Bigari Extended Family Housing, AL-17-015

Please accept the following comments from El Paso County Public Health in support of the special use project referenced above:

ADDITION TO WAGNER RESIDENCE:
2525 Evergreen Rd.
 El Paso County, Colorado

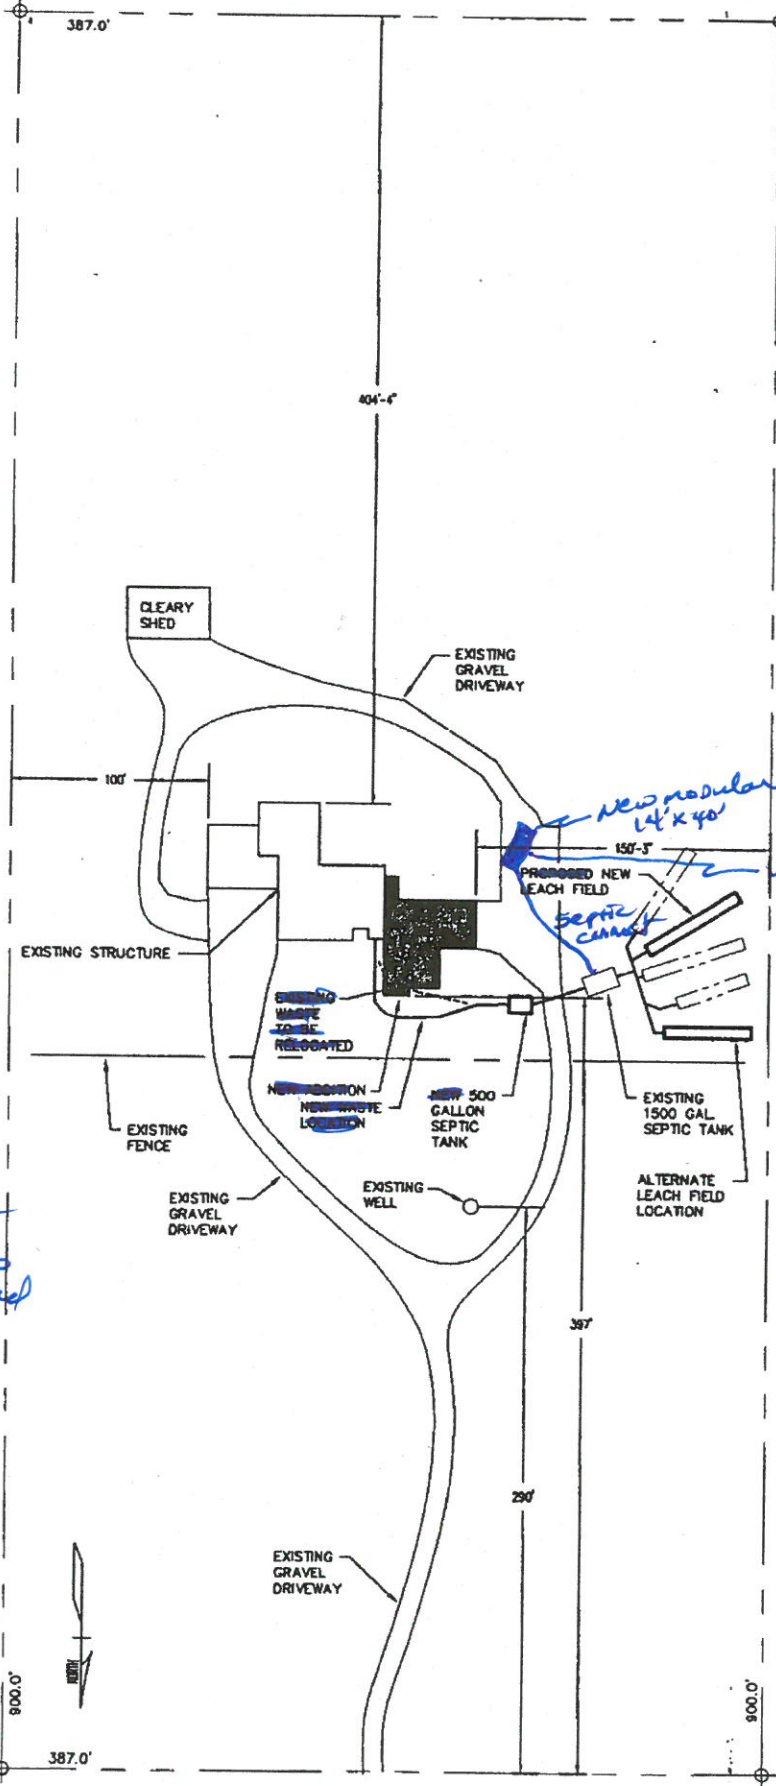
- **Water service for the existing home and the proposed 1-bedroom modular house is by an individual well.**
- **Wastewater service for the project is provided by an existing onsite wastewater treatment system (OWTS) that was installed in 1996 and sized and approved for a 4 bedroom house; however, an addition to the OWTS was made in 1999 and the OWTS was approved for 6 bedrooms. The existing house has 5 bedrooms. Therefore, the 1-bedroom modular house is approved to connect to the existing approved OWTS.**
- **An OWTS Minor Repair Permit is required to be obtained from El Paso County Public Health for the installation of the new building sewer line connection from the modular house to the existing septic tank. All minimum OWTS installation setbacks must be maintained.**
